Rustington Golf Centre Ltd  
Golfers Lane  
Angmering  
BN16 4NB

Please ask for: Nicola Moore  
Email: [nicola.moore@arun.gov.uk](mailto:nicola.moore@arun.gov.uk)  
Telephone: Ext 37944  
Our Ref: A/269/21/CLP  
Your Ref:  
Date: 11th January 2022

**Lawful Development Certificate for a Proposed Use or Development**

**Development:** Lawful development certificate for a proposed front porch extension and rear single storey extension and alterations  
**Location:** 5 Ham Manor Farm Cottages West Drive Angmering BN16 4JF

Brian Heap Architectural Consultant Tel: 01905 830000 brianheaparchitect@btconnect.com		5 Ham Manor Farm Cottages West Drive Angmering BN16 4JF	
Floor Plans as Existing		December 2021	
Drawing No. 21-20114-01 A		1:50 at A3

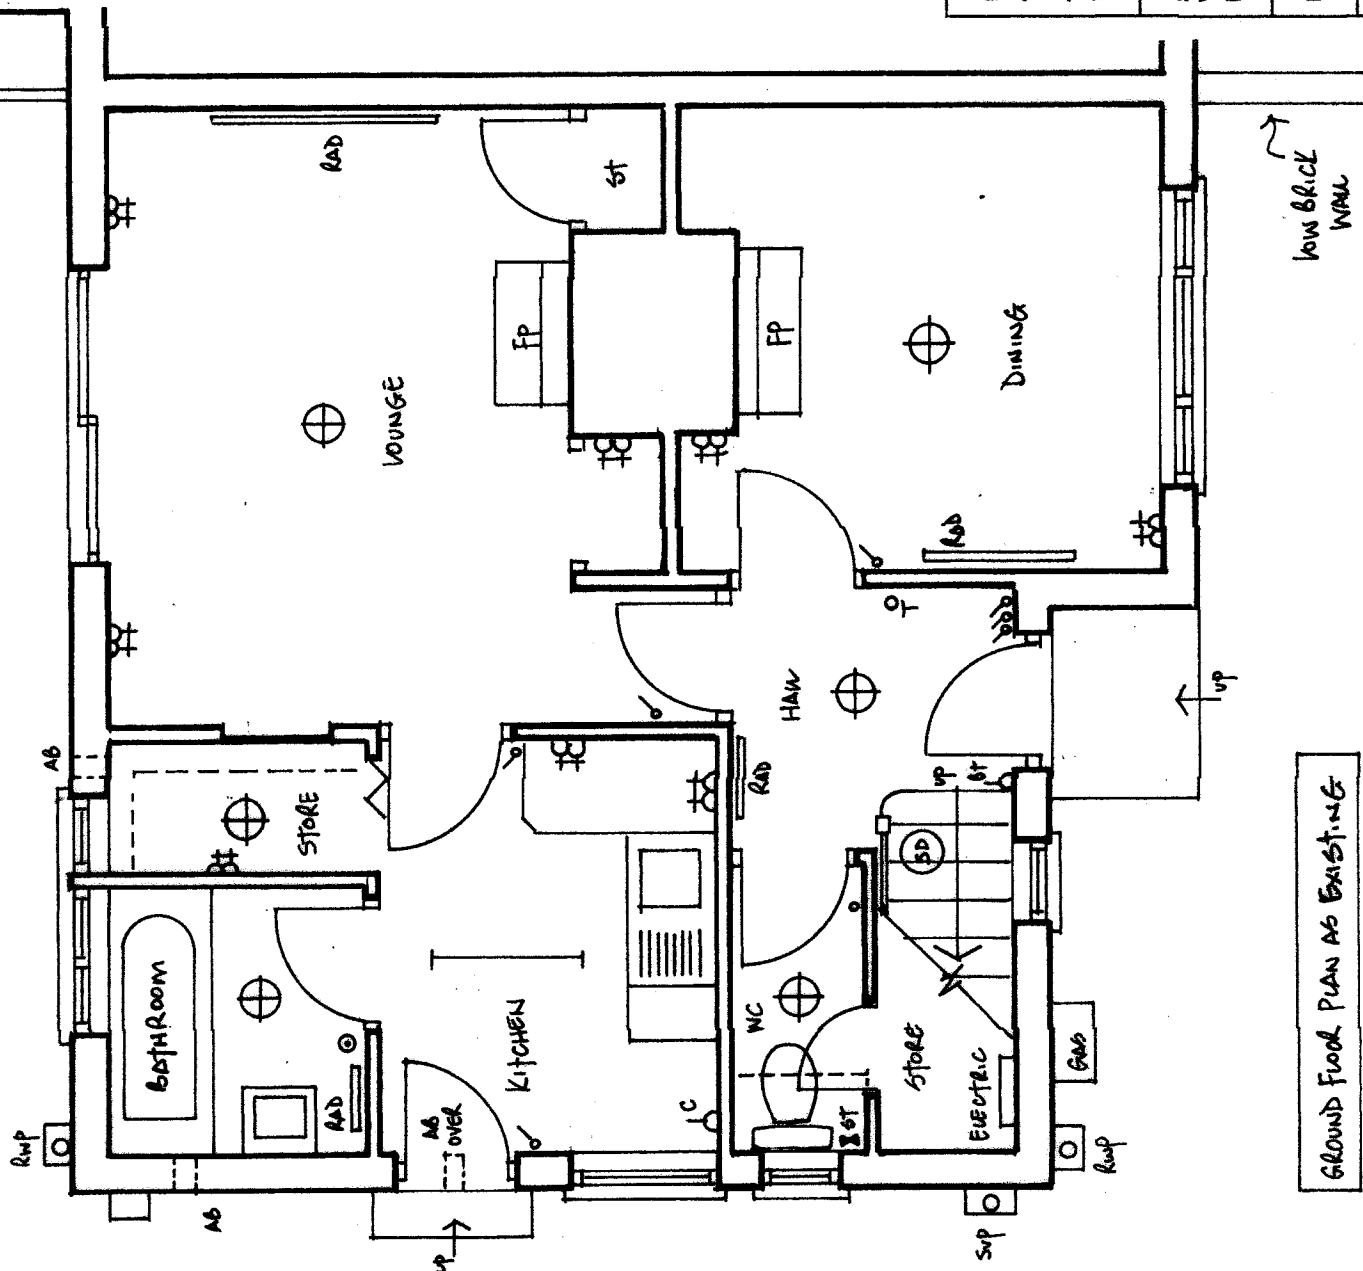
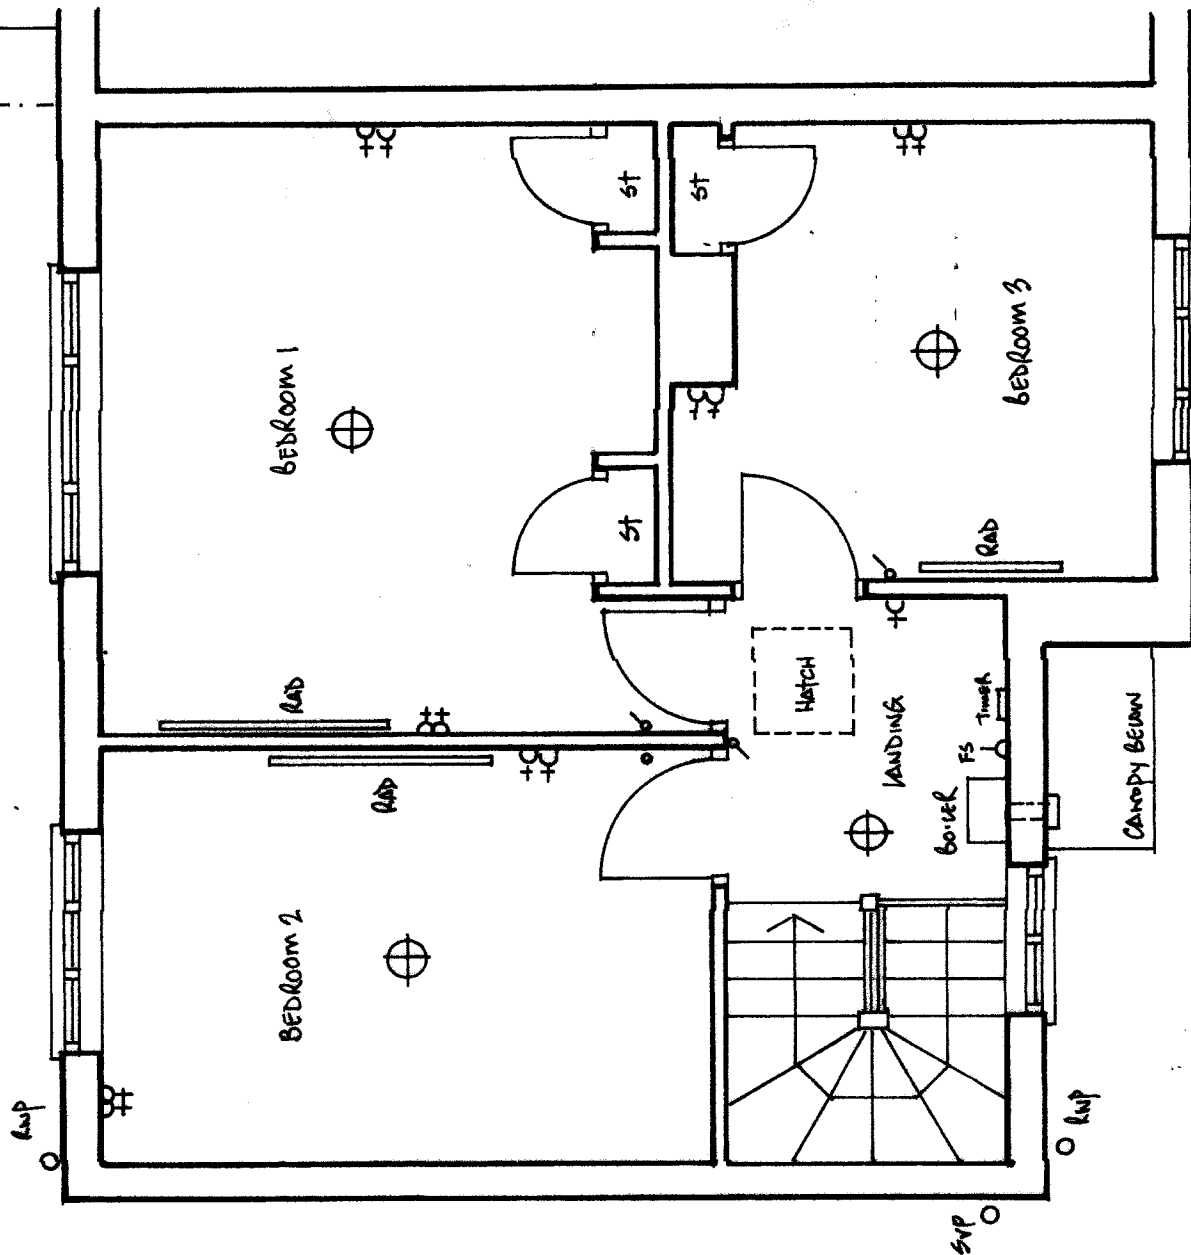
Dwg No 21-20114-01 is titled Floor Plans as Existing but shows the drawings are labelled Existing First Floor and Proposed Ground Floor. Please amend accordingly and re submit.
